**Application by Tritax Symmetry (Hinckley) Limited for an Order Granting  
Development Consent for the Hinckley National Rail Freight Interchange –  
Deadline 3 submission**

Please find below and attached submissions on behalf of Leicestershire County Council (LCC) in relation to Deadline 3 of the Examination Timetable as set out in the Rule 8 letter dated 22 September 2023.

Written Statement of Oral Case ISH6 [Appendix C – Plan for A47 link road footway/cycleway design]

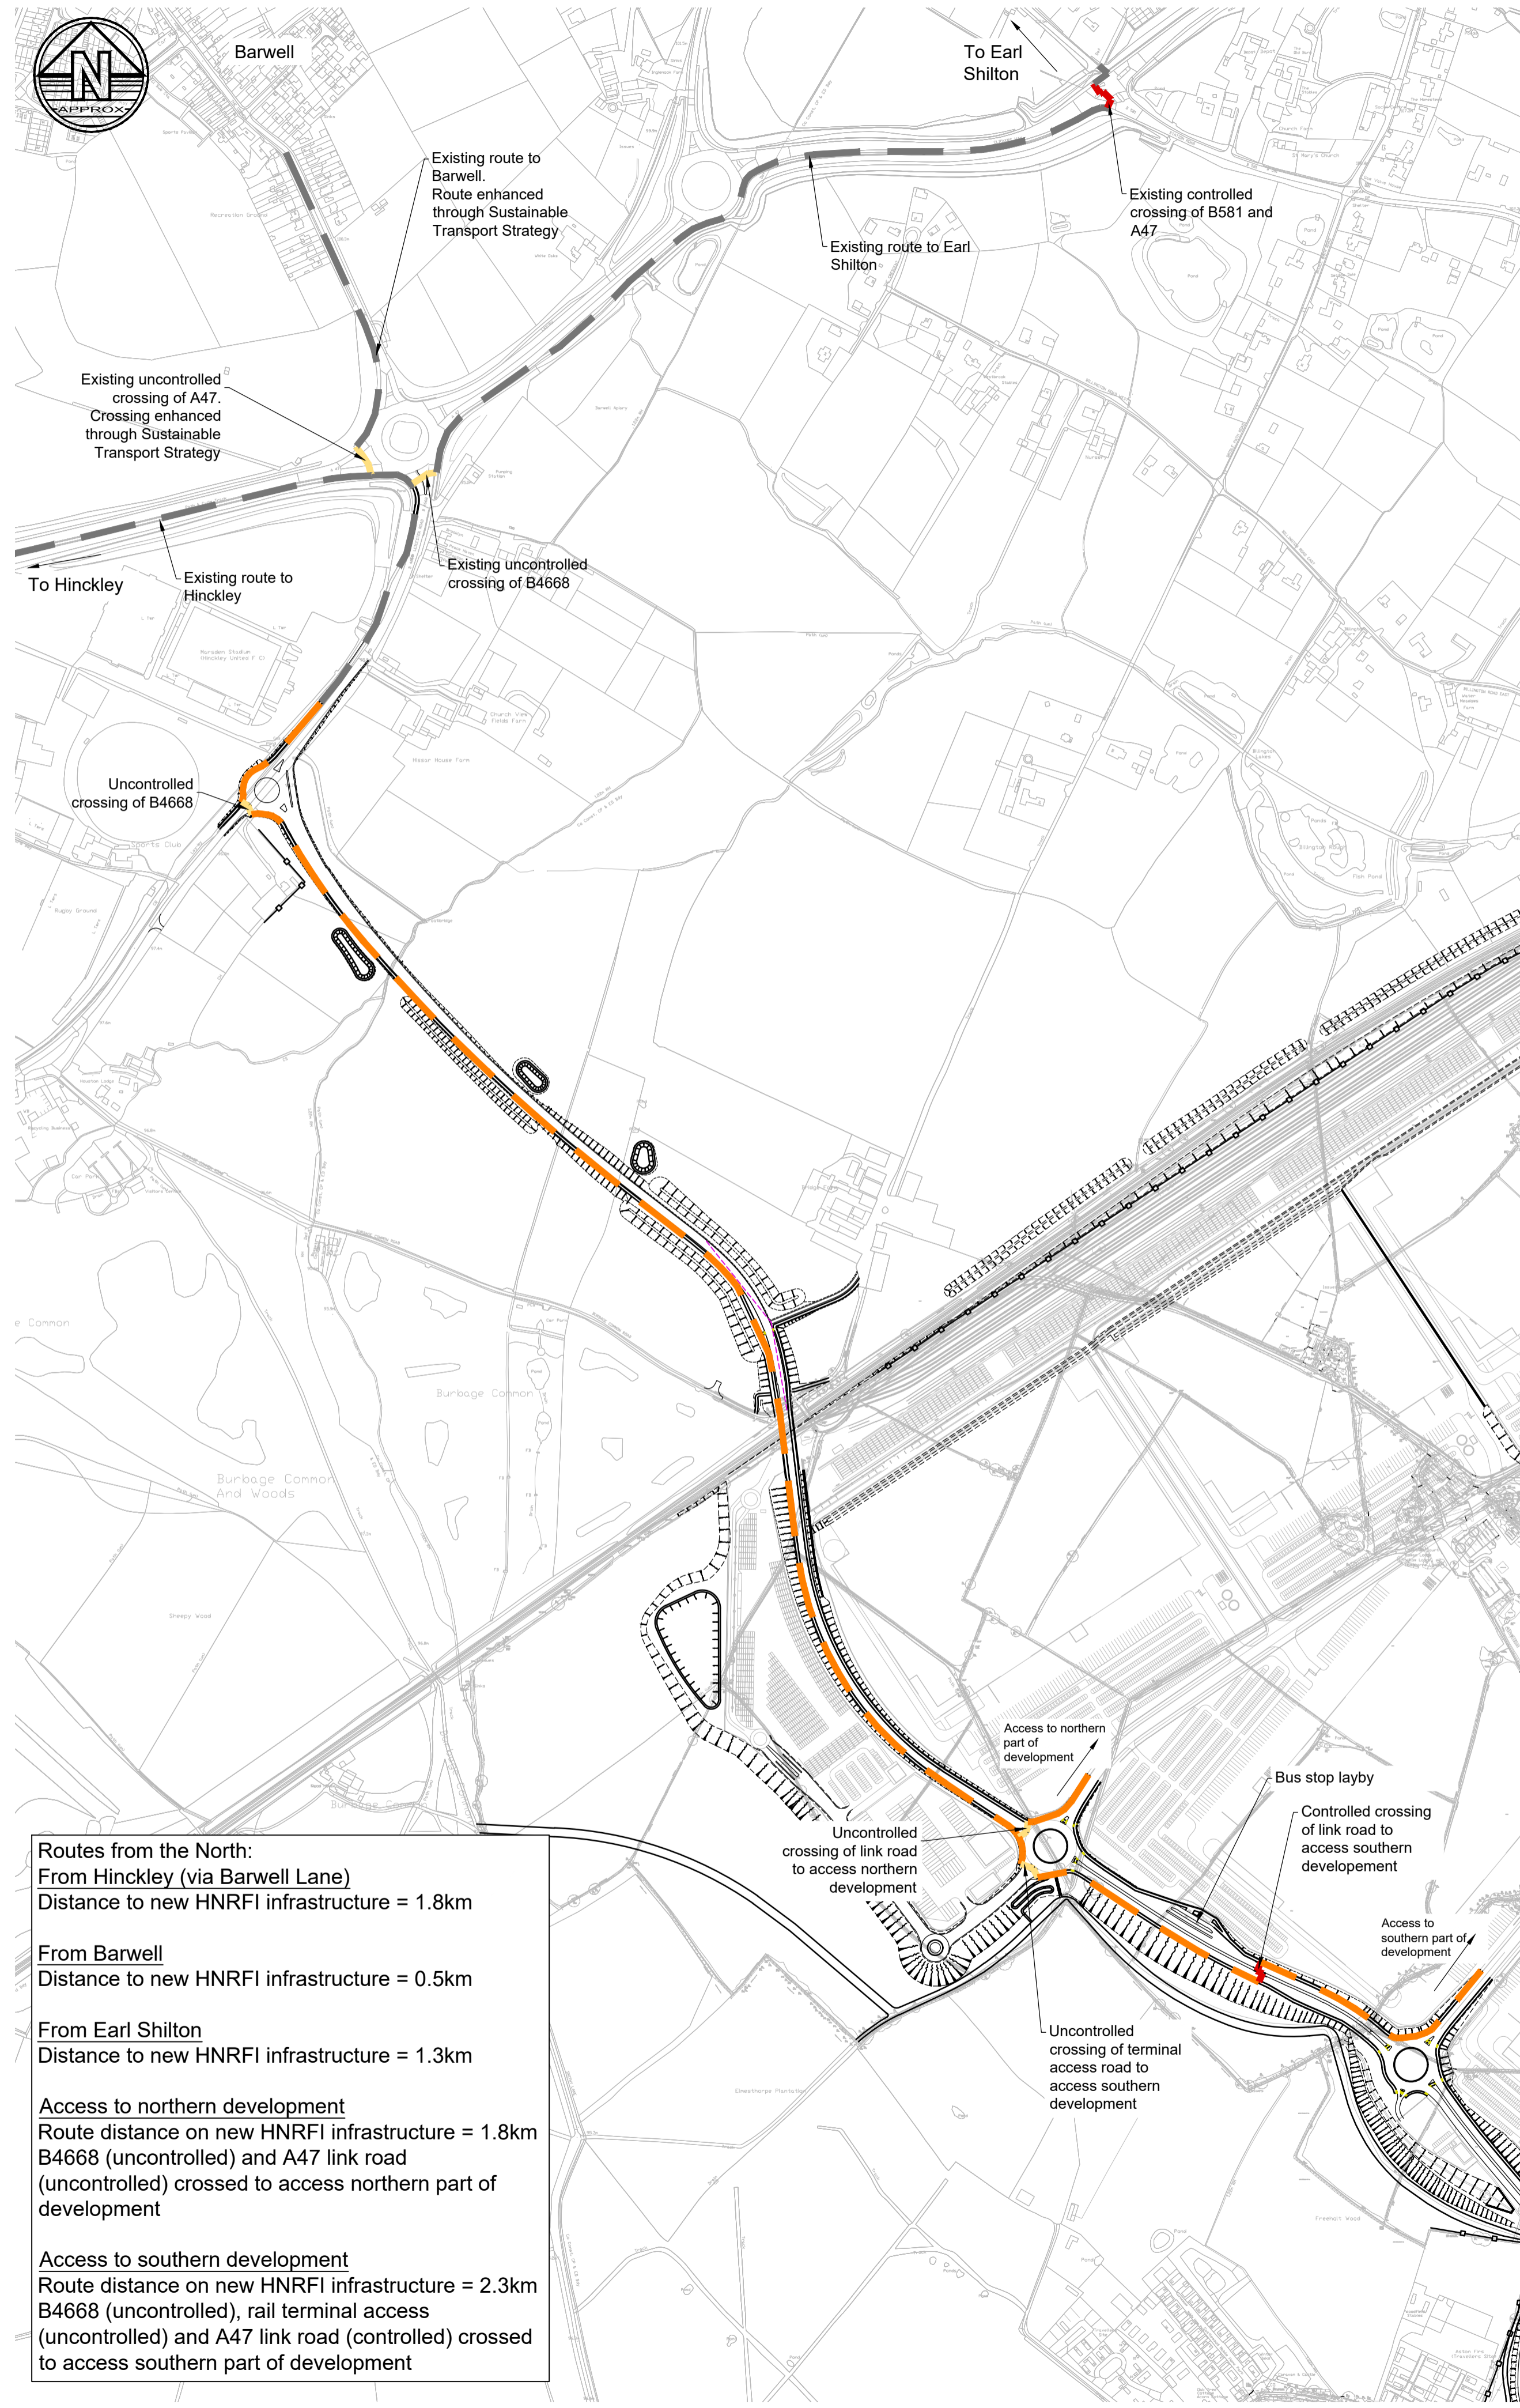
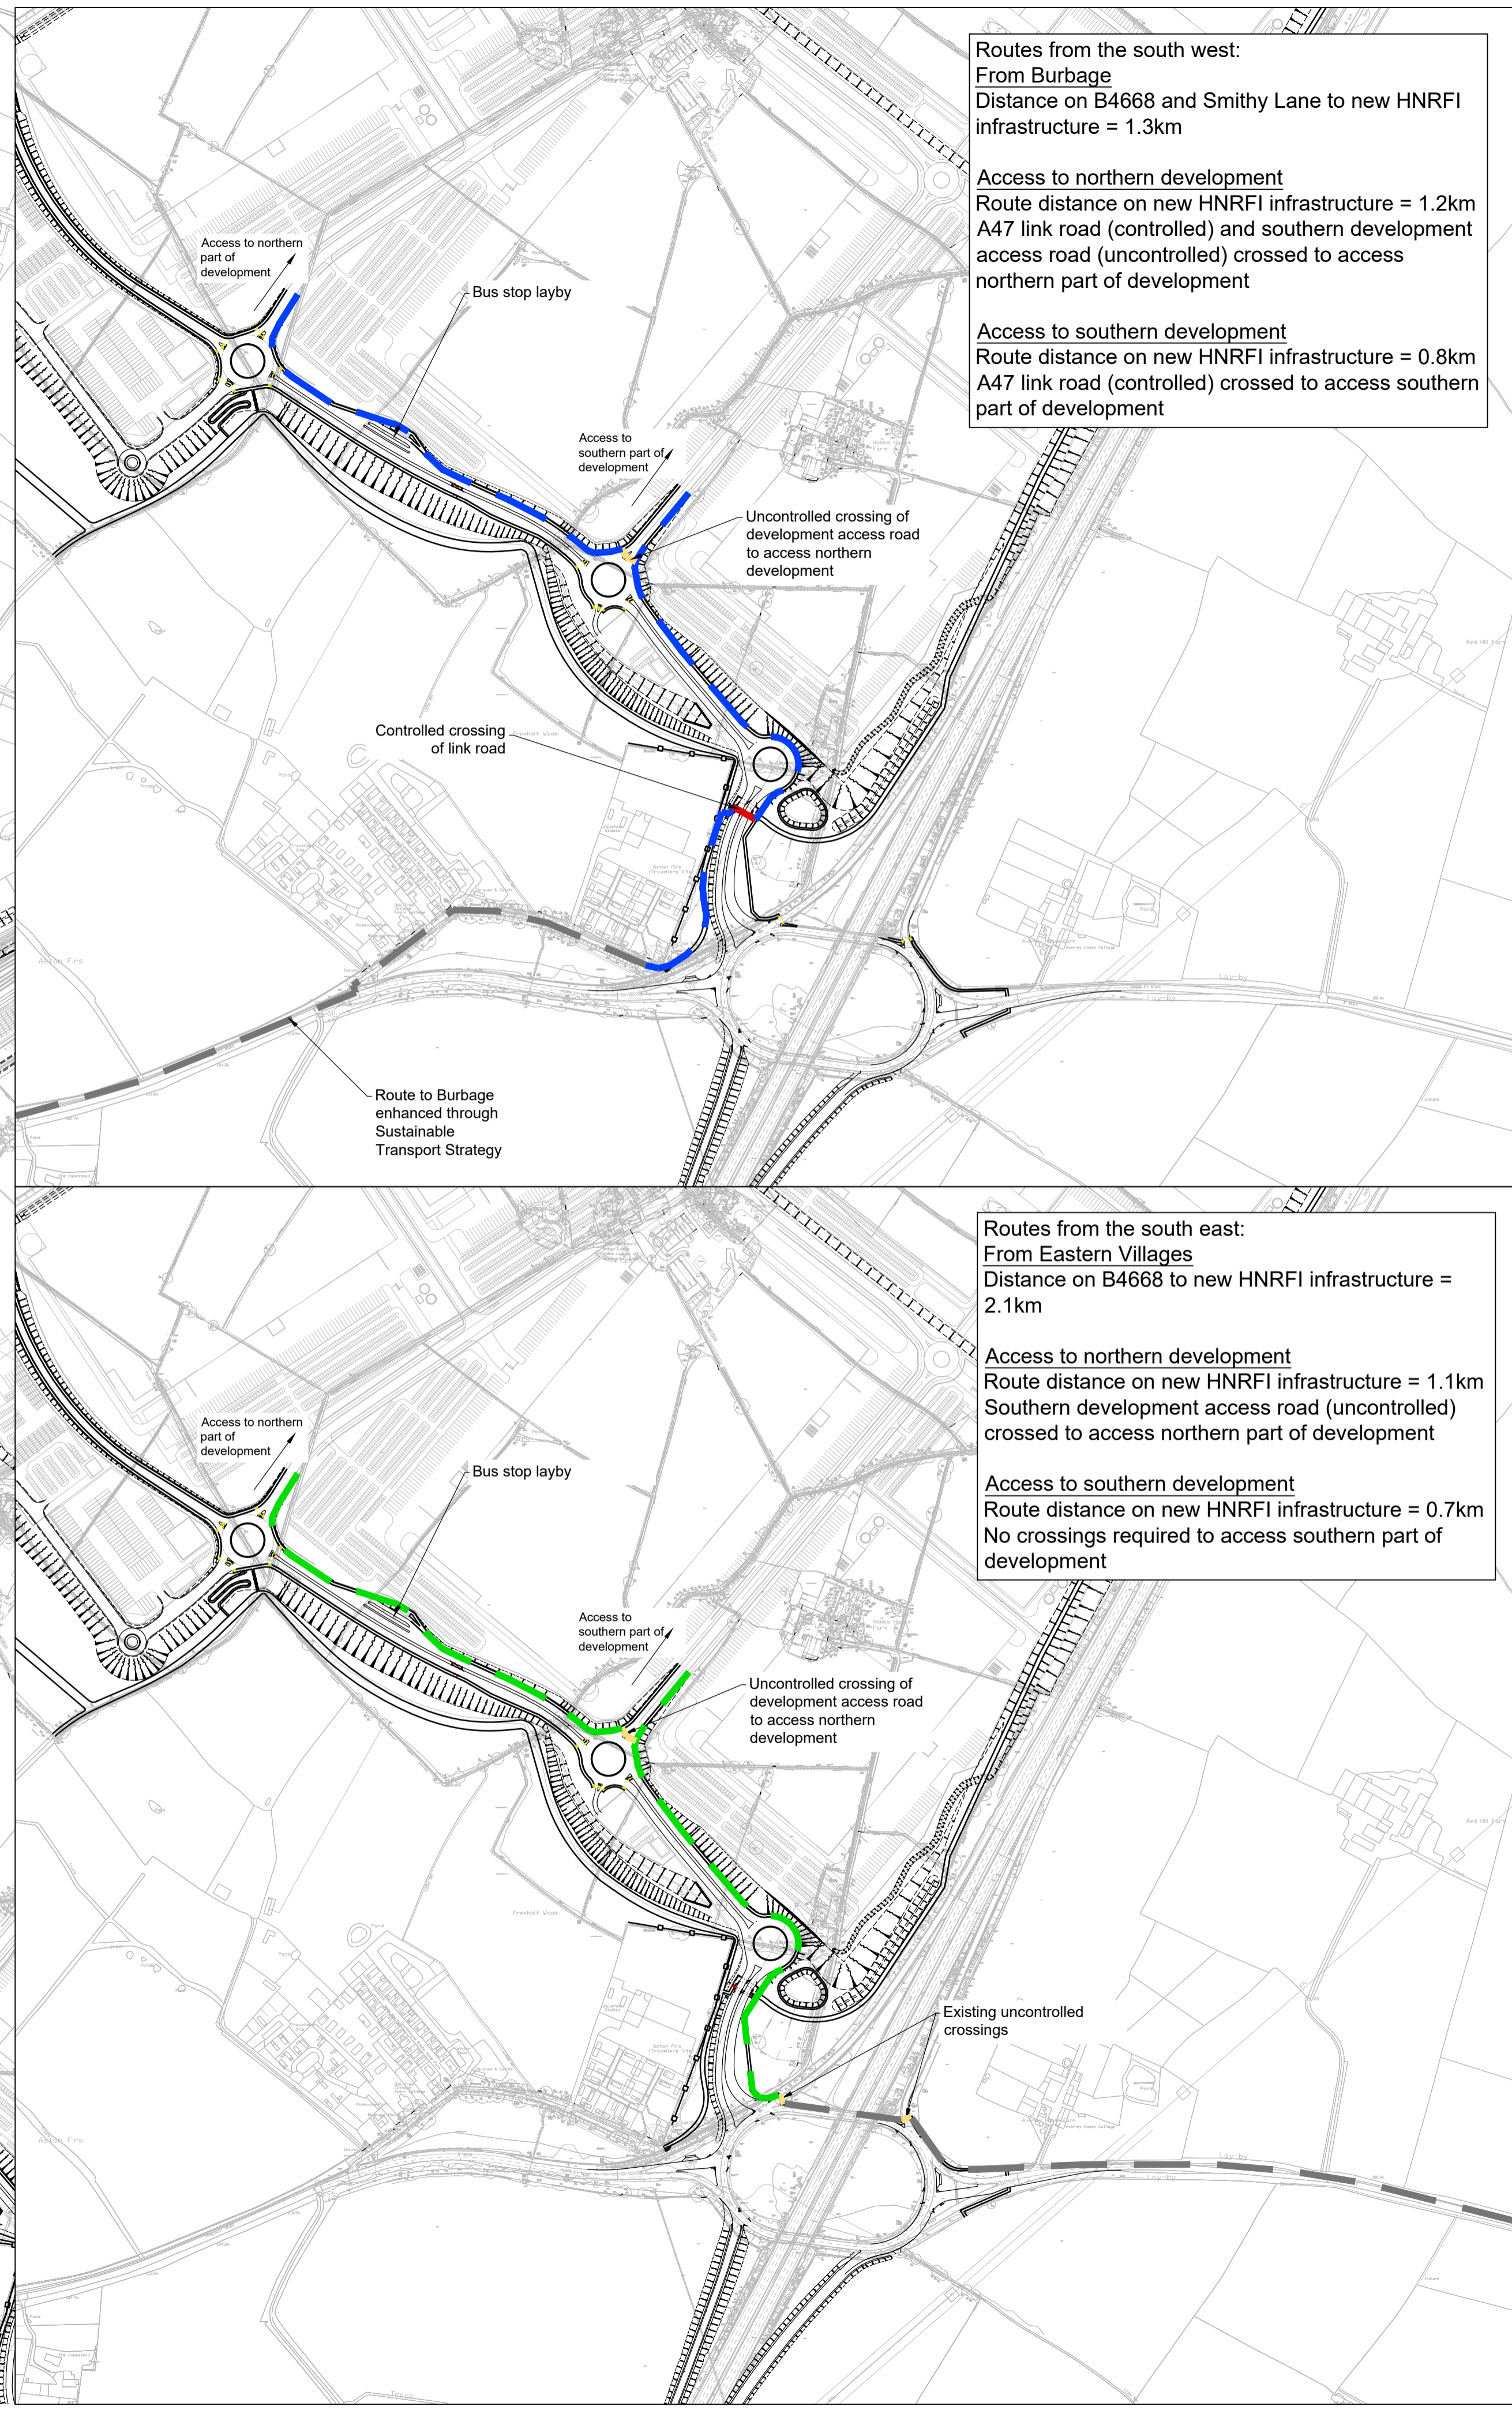
4. Agenda item 5b: Cycling: LCC await the promised larger scale drawings in order to confirm the extent of the Footway/ Cycle provision, but it does not appear to connect to local villages. In LCC's view it should: it is a relatively low-cost way of connecting the development sustainably to parts of the potential work force.
